Development Facilitation Team (DFT) – Review Comments

Project No: PR-2023-009260AKA PR-2021-006156 Date: 11/13/23 Agenda Item: 4 Zone Atlas Page: K-11

Request: Consolidate 40 Lots into 2 Lots, incorporate vacated Right-of-Way into the subject property, and provide easements as shown

Application For: SD-2024-00160 – PRELIMINARY/FINAL PLAT

ALBUQUERQUE HOUSING AUTHORITY
REPLAT OF LOTS 6-17, BLOCK 1, AND LOTS 6-14, BLOCK 2, METZ-ROBERTSON ADDITION AND LOTS 1-15 & 17-32, PATILLY SUBDIVISION WITHIN PROJECTED SECTION 23, TOWNSHIP 10 NORTH, RANGE 2 EAST, N.M.P.M. CITY OF ALBUQUERQUE, TOWN OF ATRISCO GRANT, BERNALILLO COUNTY, NEW MEXICO

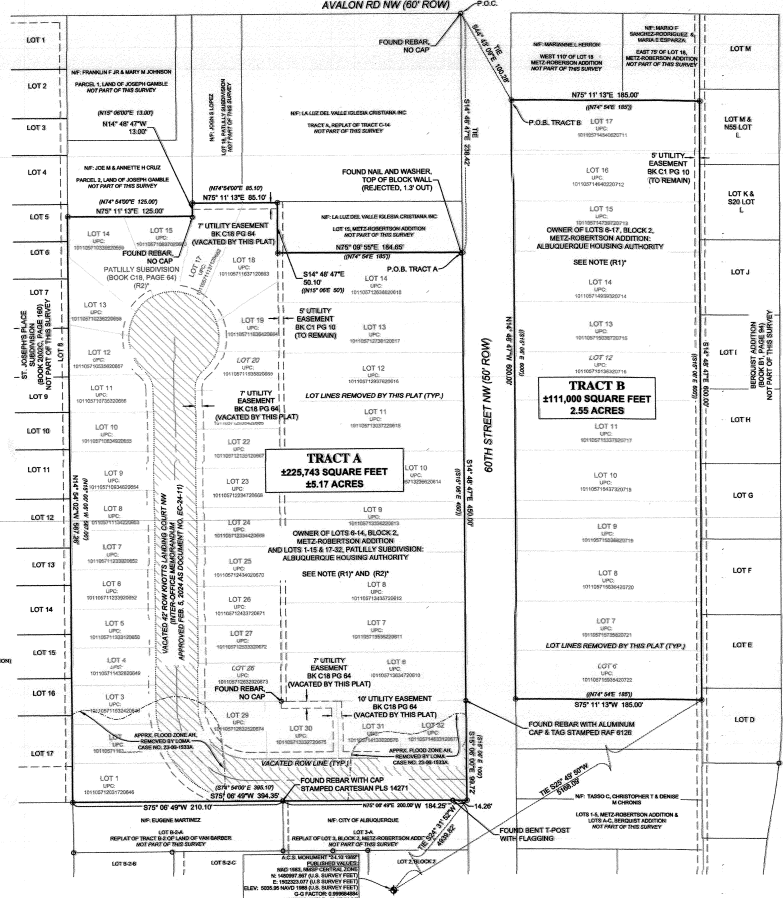
1. Please confirm lot B2A has access to public water and sanitary sewer or provide an easement for that lot.

1. Transportation has no objection to the plat, but as a condition of approval the plat must state the beneficiaries and maintainance responsibilities for the access easement.

Project numbers and Stamped documents have been provided but are lacking the application # on all documents and are in small print. Please add the application # to the required documents and add the application/project numbers to a more prominent spot on the Plat sheets above the signature boxes.
